From: Charlotte Watkins <Charlotte.Watkins@Cherwell-DC.gov.uk>
Sent: 10 February 2020 11:12
To: Caroline Ford <Caroline.Ford@Cherwell-DC.gov.uk>
Subject: RE: 19/02958/F - Bicester Gateway Business Park, Chesterton

Dr Charlotte Watkins
Ecology Officer

**External Services Layout**

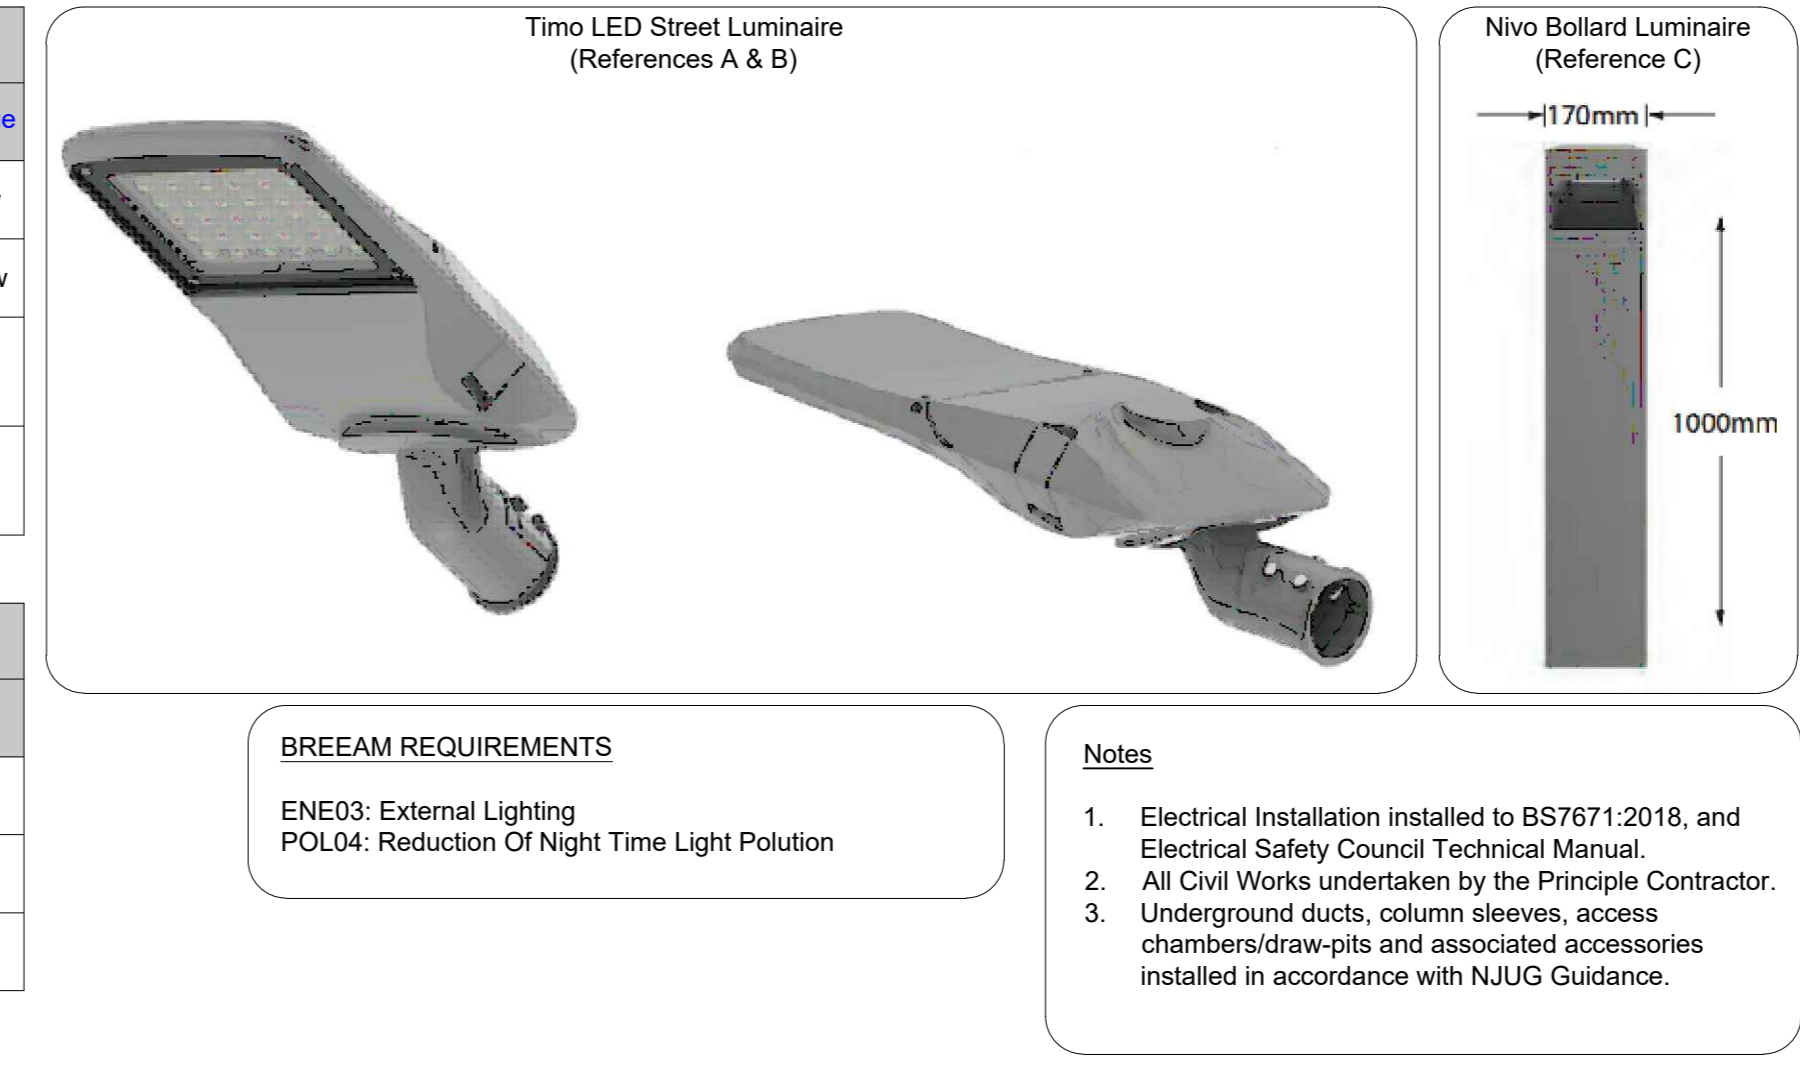
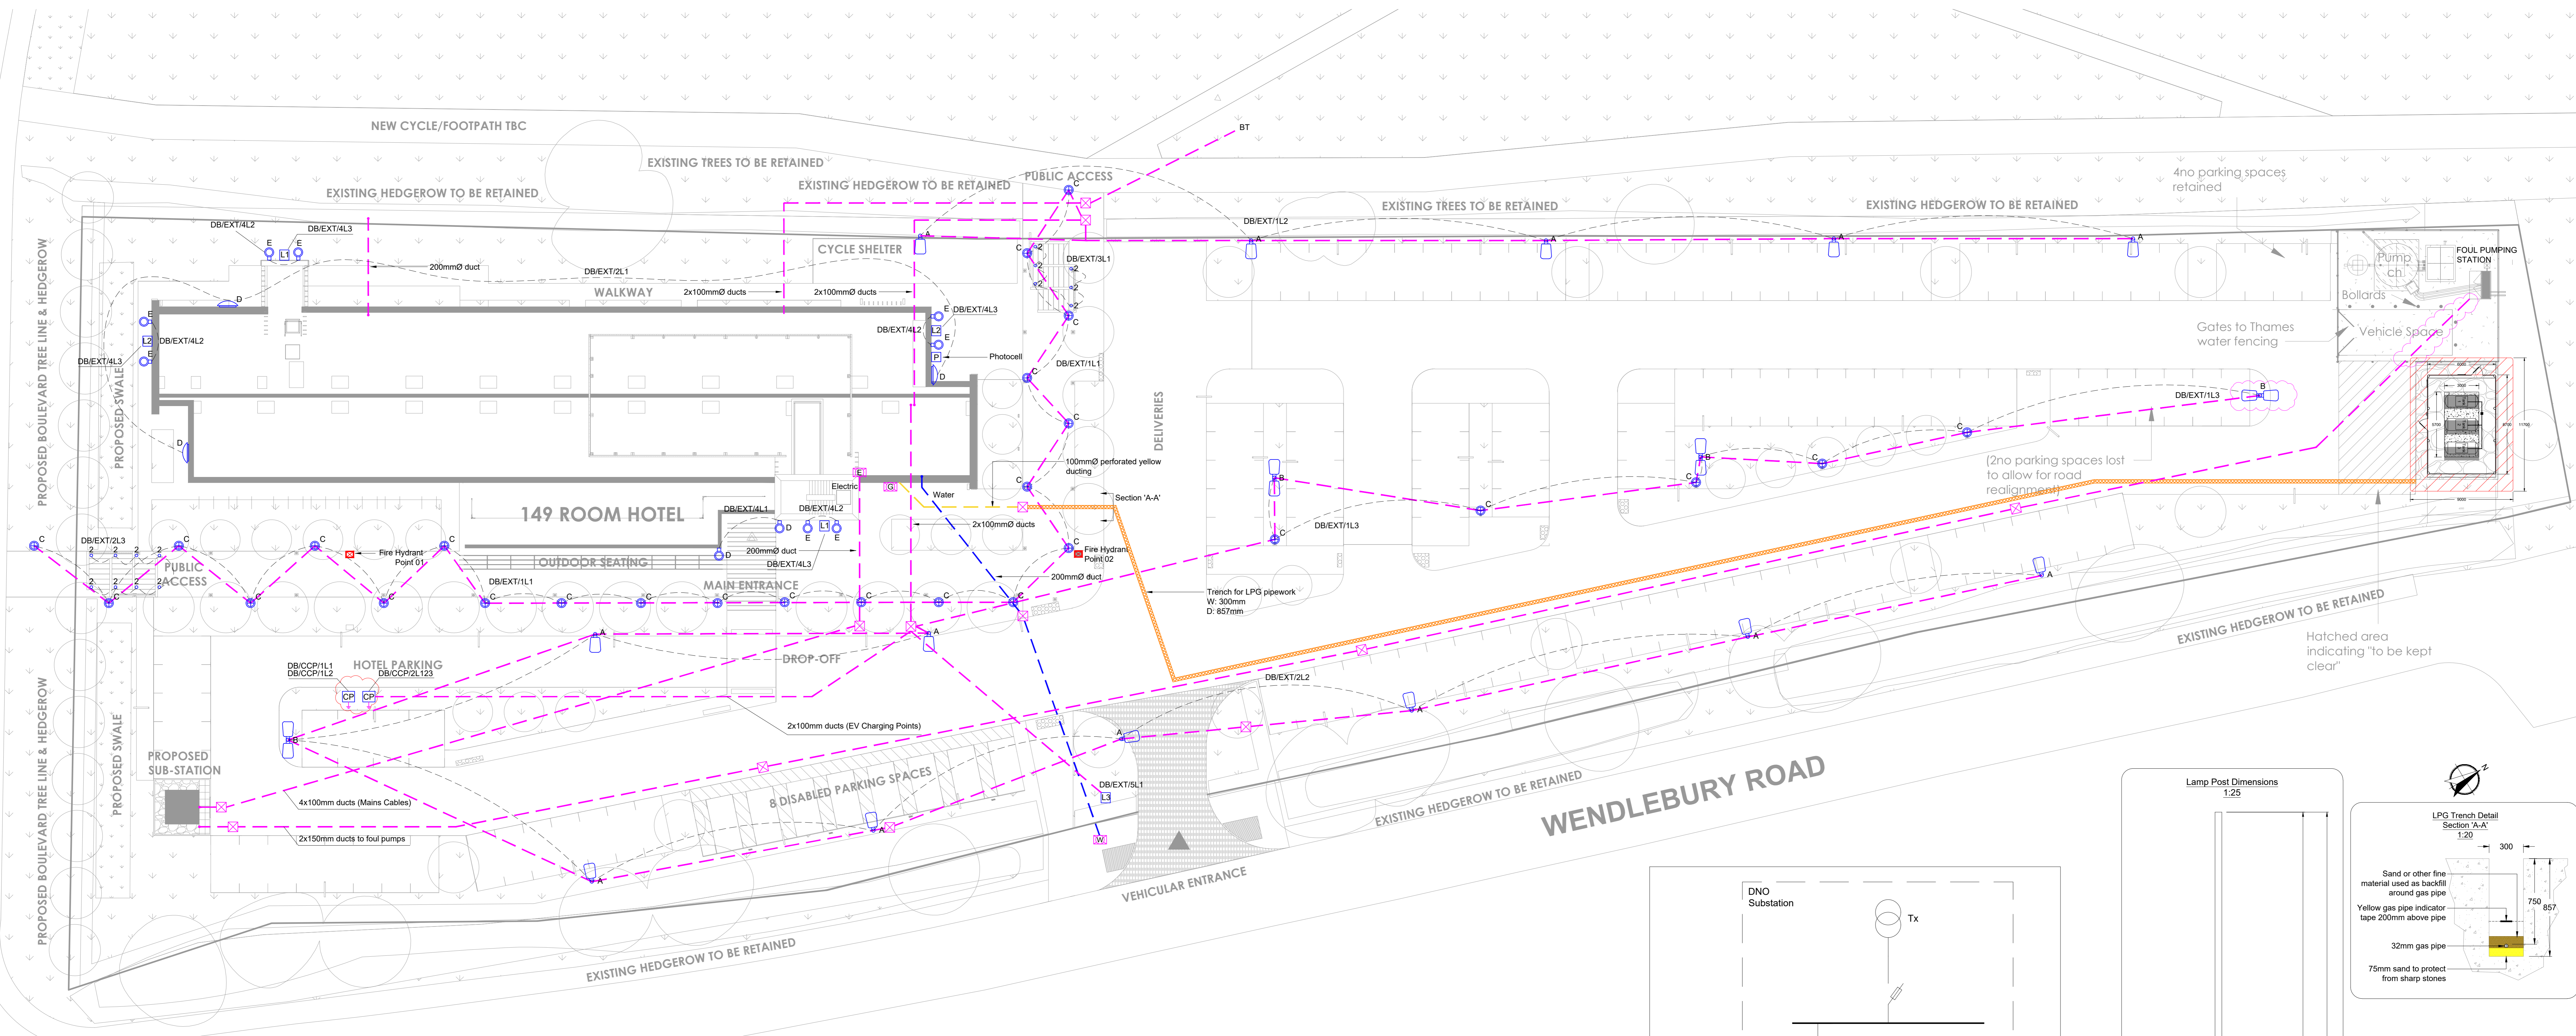
I cannot tell which lighting arrangements have changed but looking at this layout the 6m columns to the West of the site which are within or adjacent to the 'existing hedgerow to be retained' are likely to unavoidably cause an unacceptable amount of light spill into the hedgerow if sited in that location. It would be better if they were sited further into the carpark (and their number reduced). I agree with the Arboricultural Officer that the storing of the hedgerow for later re-installment requires more information especially an estimate of how long storage is likely to be needed for as this will affect the likely success. We definitely need a plan for full replacement of the hedgerow to be submitted (to include a survey of species currently present and preferably to be of better biodiversity value to present) should the replanting of it not work. This would require monitoring of its success over the next couple of years.
